## City of Albuquerque

Re: Trotter Addition, Lots 9 and 10, Blk. 2  
(J14-D28)

Re: Drainage Plan for Lots 9 and 10, Block 2, Trotter Addition,  
Dated December 7, 1982

## DRAINAGE PLAN

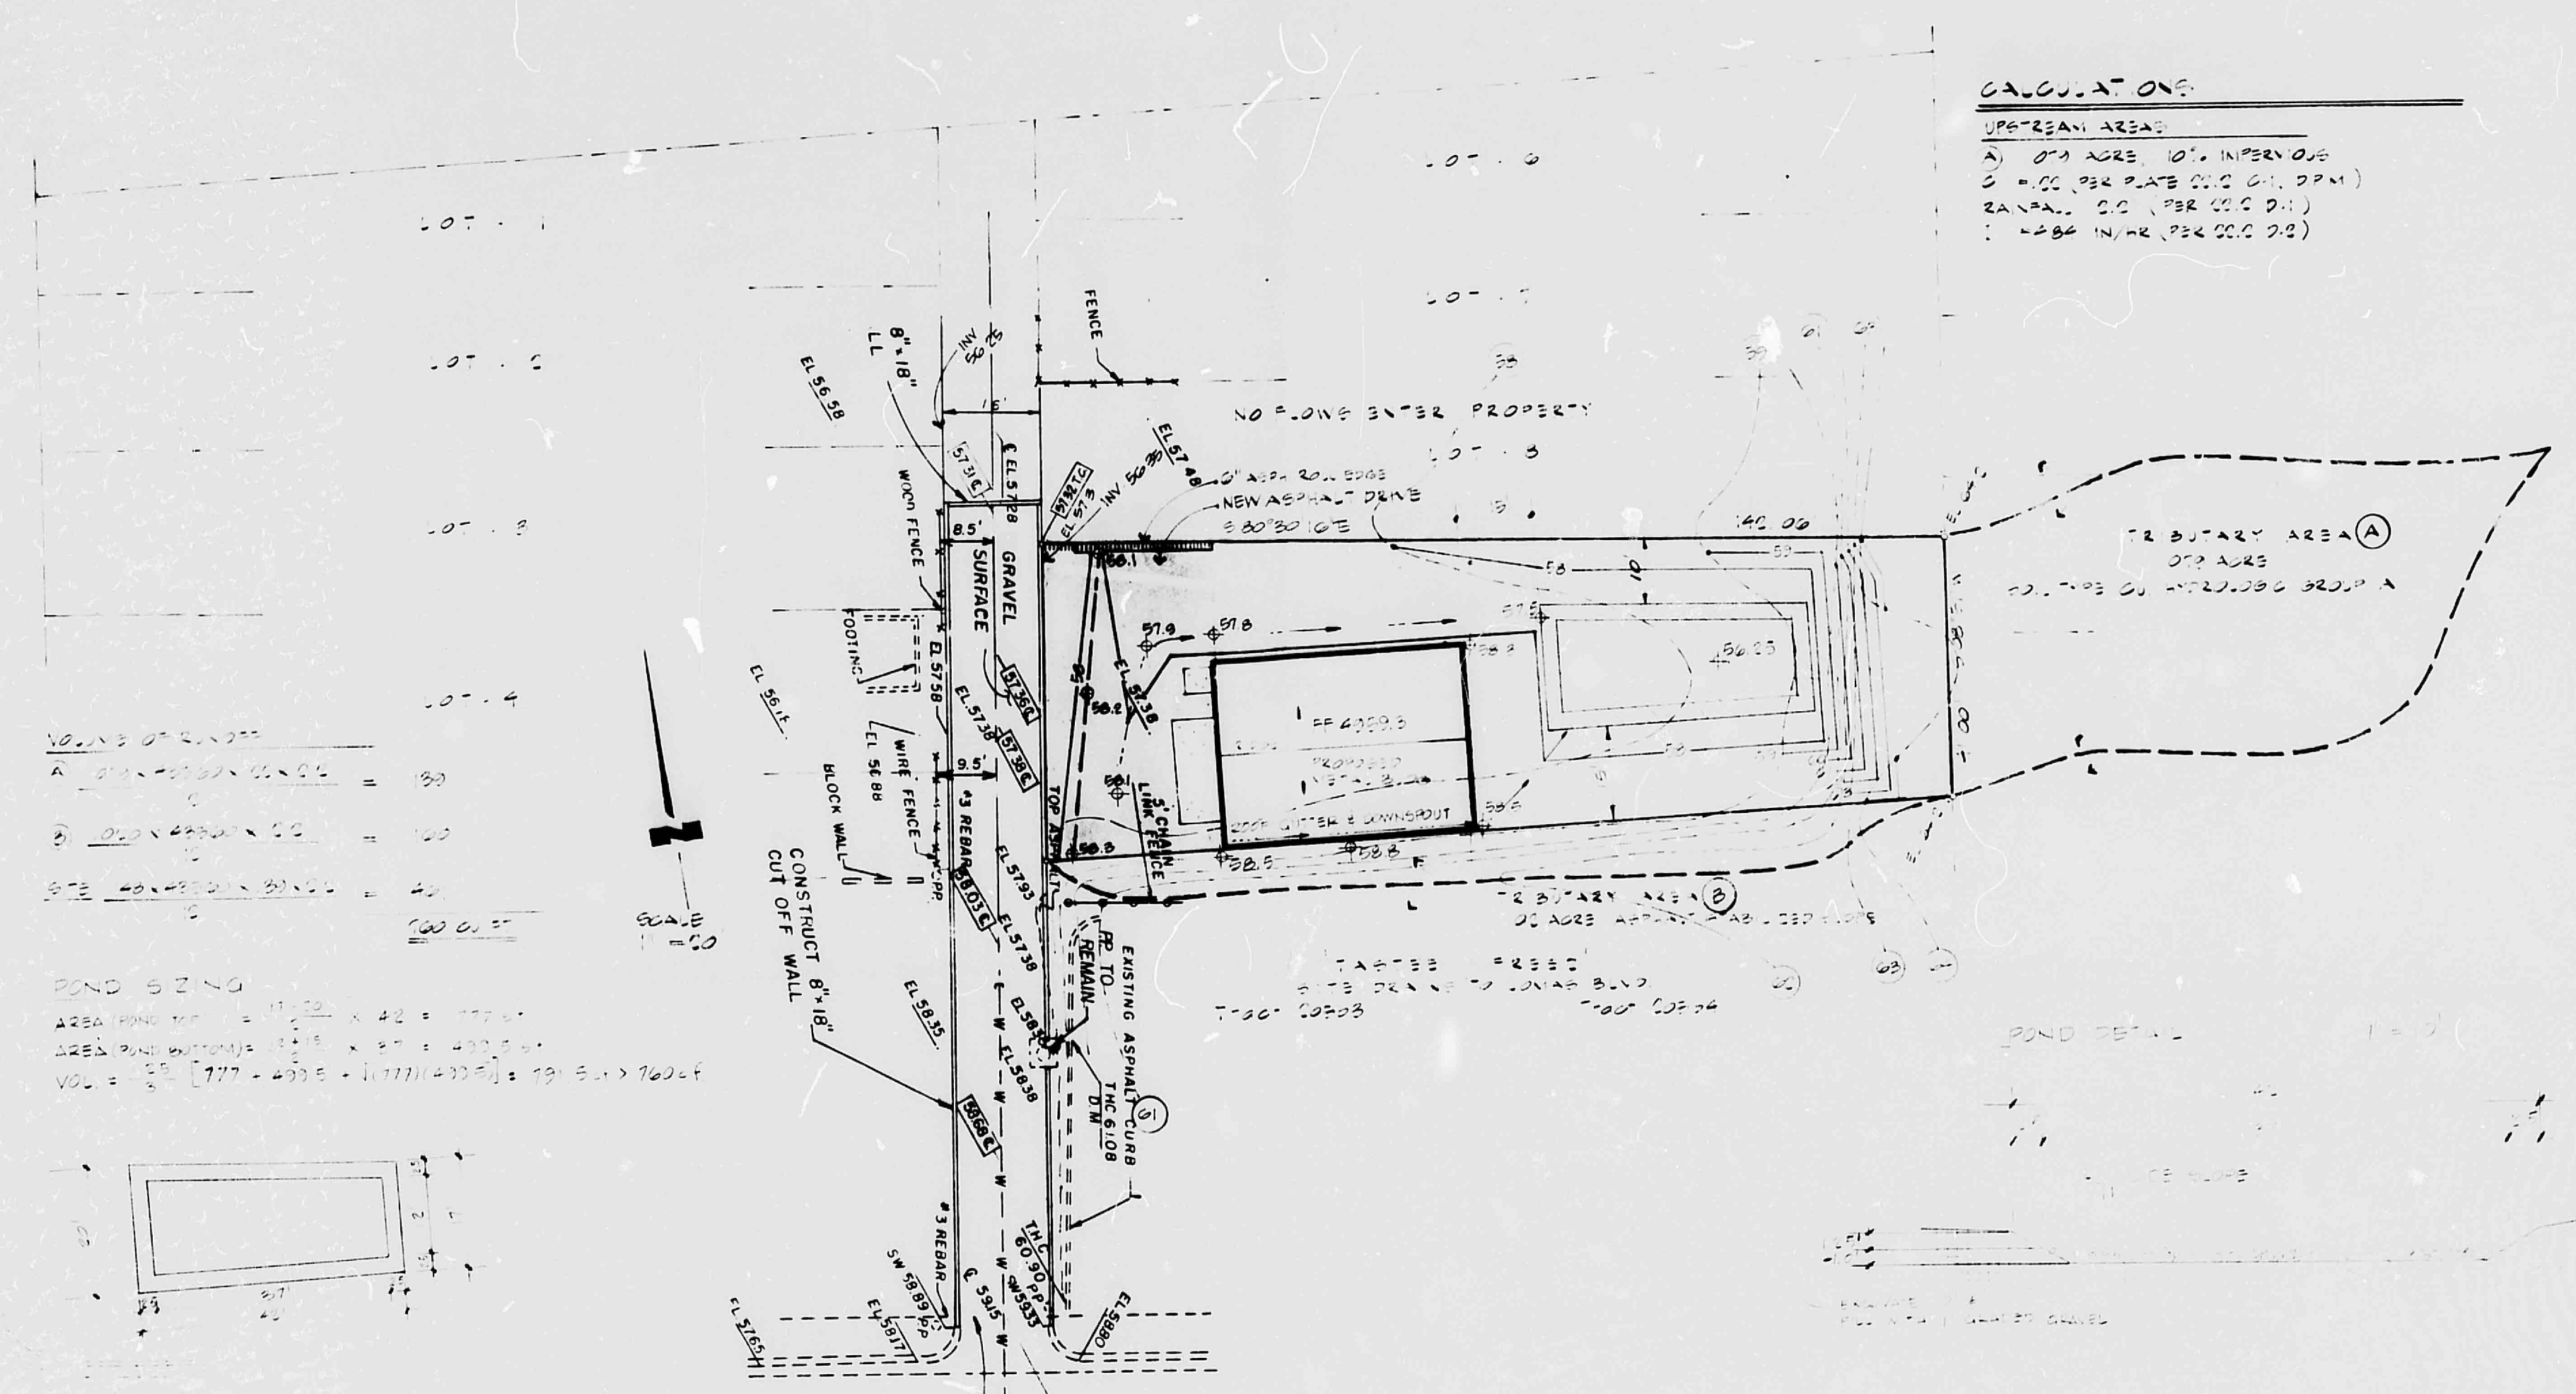
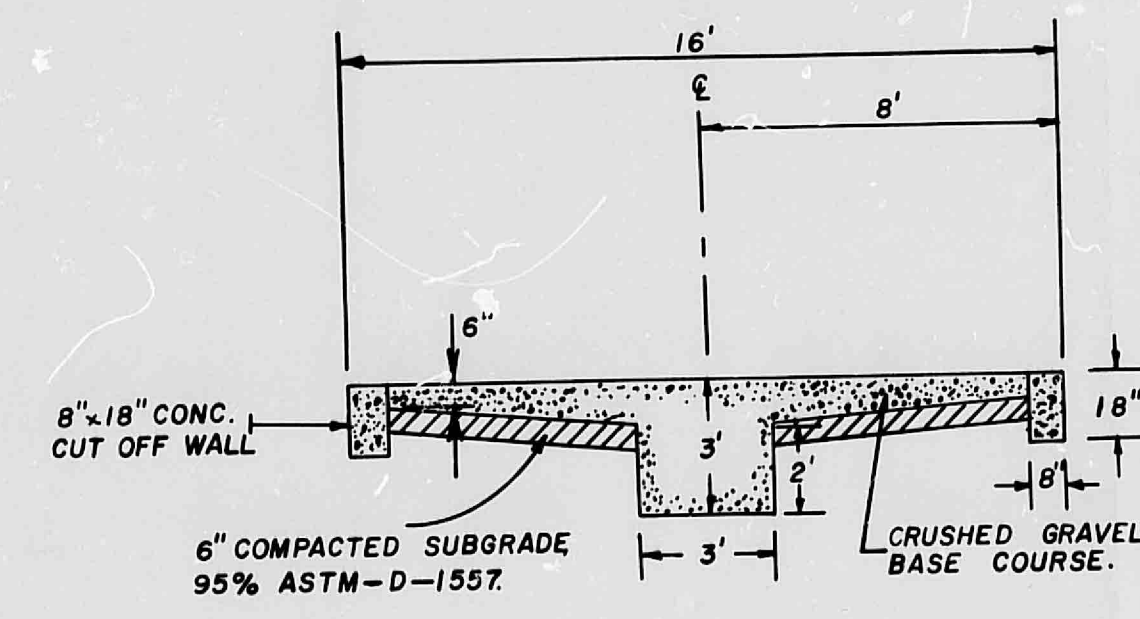
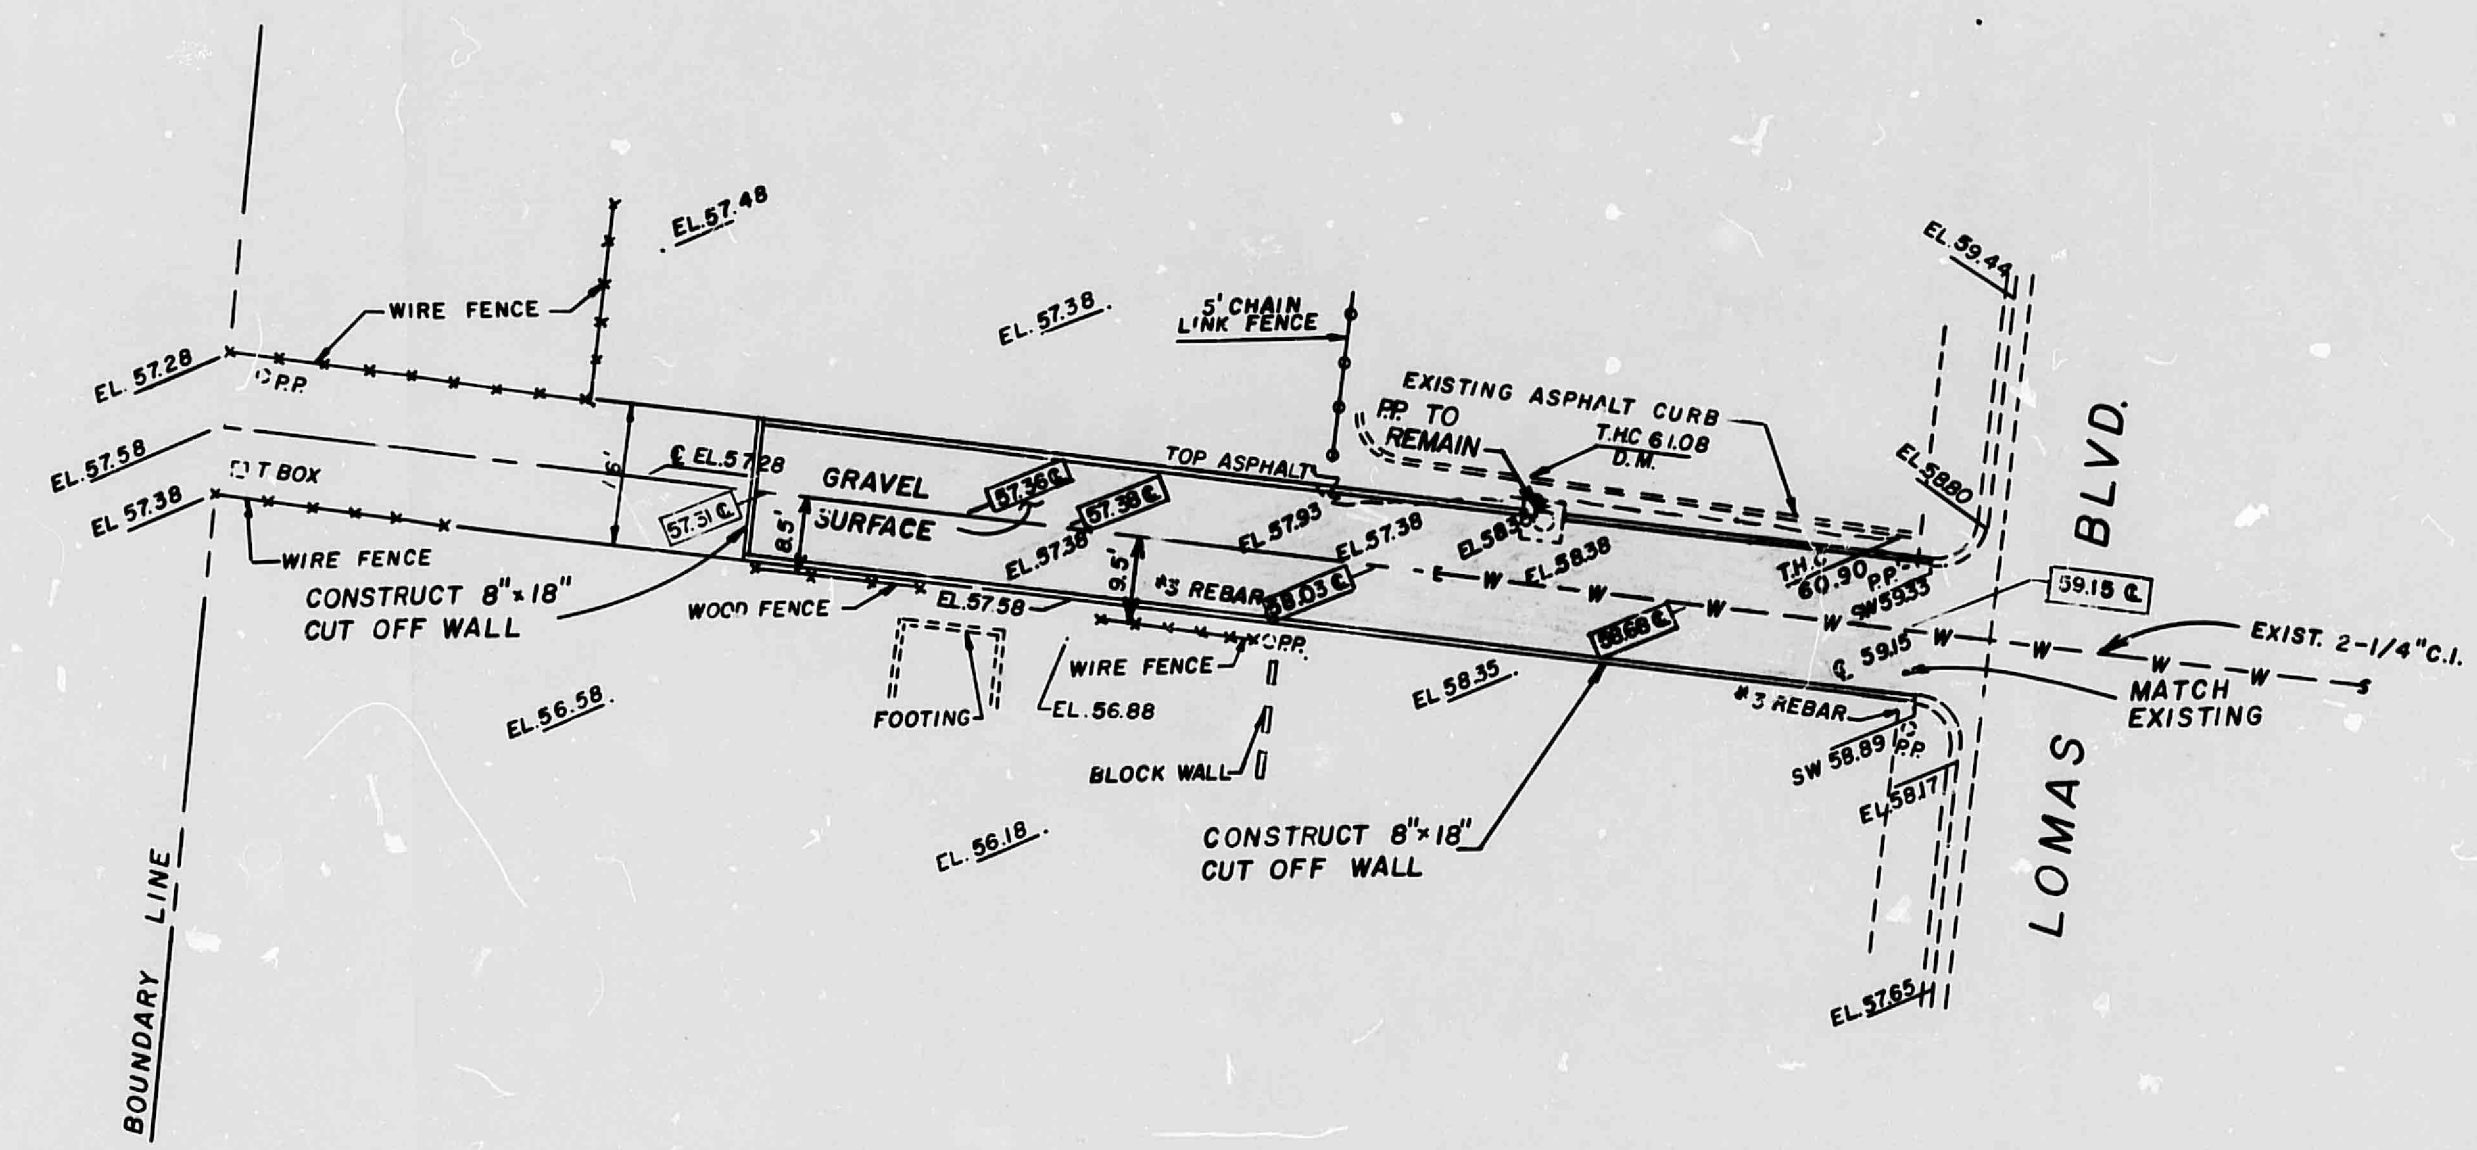
1. Inclusion of City approved alley grades with your drainage plan.
2. Revised pond storage calculations based on the routing of the developed runoff through a pond and released within 24 hours with a minimum pipe diameter outlet of 4".
3. Removal of lot lines by summary plat or provide a private drainage easement for the common drainage and/or ponding.
4. Discussion of the downstream conditions with respect to flooding.
5. Provide a completed copy of the Information Sheet found in Section 22.7 in the Development Process Manual.

The referenced plan received December 10, 1982 is being returned for noncompliance with the Drainage Ordinance which requires discharge of the pond.

Please provide a revised plan with provisions for discharge into a public right-of-way as required by the Drainage Ordinance and outlined by the Development Process Manual, Volume 2, Section 22.7.
